# SYDNEY METRO PITT STREET SOUTH OVER STATION DEVELOPMENT

Response to RFI (SSD 10376 &  
SSD 8876-2)

12 November 2020

Figure 4-15: On-site bicycle parking provision on level 3 (drawing no: SMCSWSPS-BAT-OSS-AT-DWG-930341, Revision C)

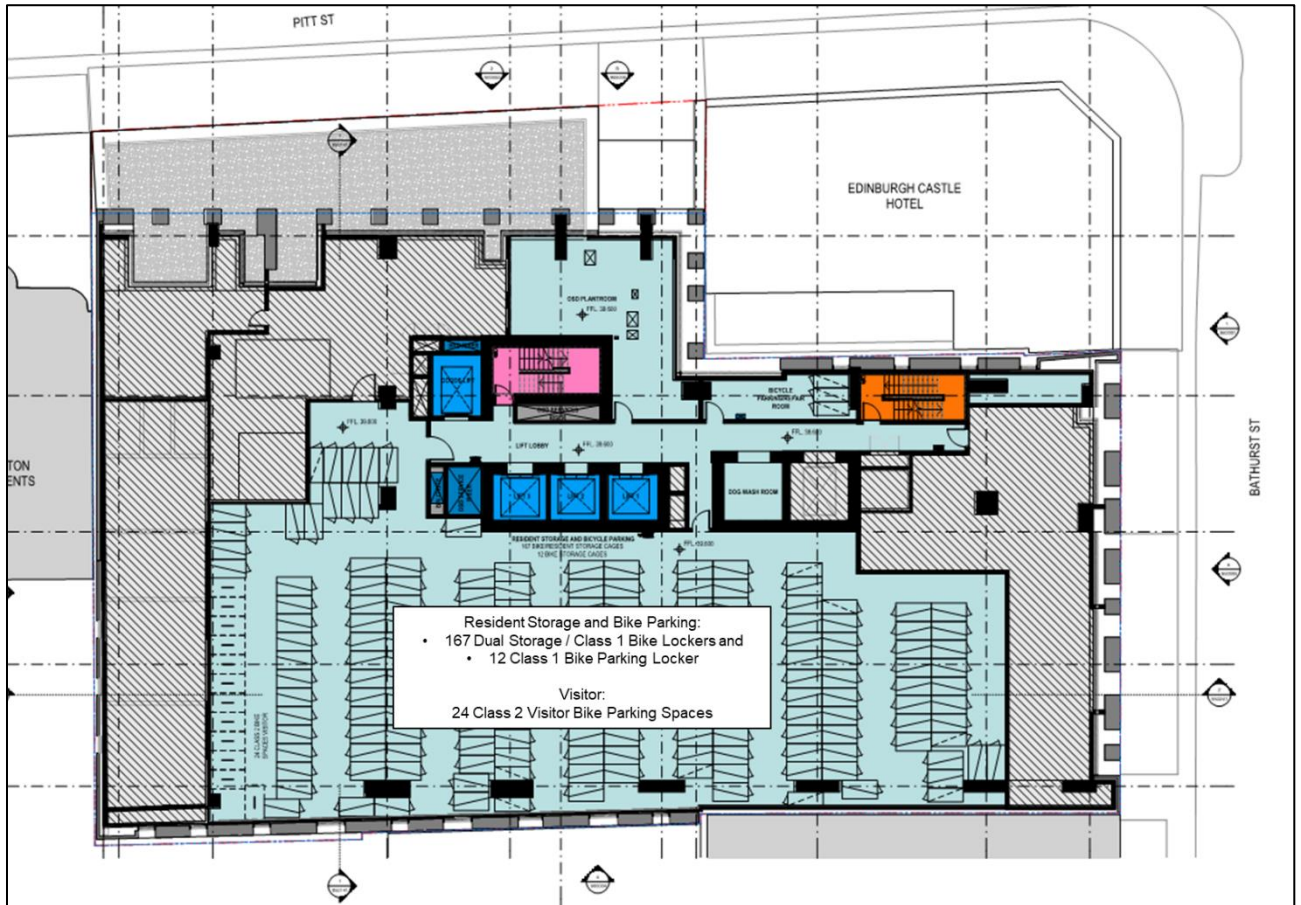
The DPIE have requested confirmation on how the proposed 12 retail bicycle parking spaces will be accommodated within the development.

Within the RTS it was proposed to have the 12 retail bicycle parking spaces within the retail use on Level 2. This has been reviewed from an operational perspective and confirmed that it is more effective to house these bicycles with the resident bicycles on the Level 3 – Bike parking and apartment storage level.

To be able to accommodate the additional bicycles, the storage within one apartment type (1BT1) has increased to accommodate 100% of the storage required by the Apartment Design Guide within the apartment, allowing this apartments storage provision to be removed from Level 3 allowing space to provide the retail bicycle provision.

The revised layout for Level 3 provided at **Appendix E** demonstrates that the following can be provided within Level 3:

- 104 dual bike and storage lockers;
- 75 vertical bike lockers;
- 12 resident visitor bike racks; and
- 12 retail bike racks.
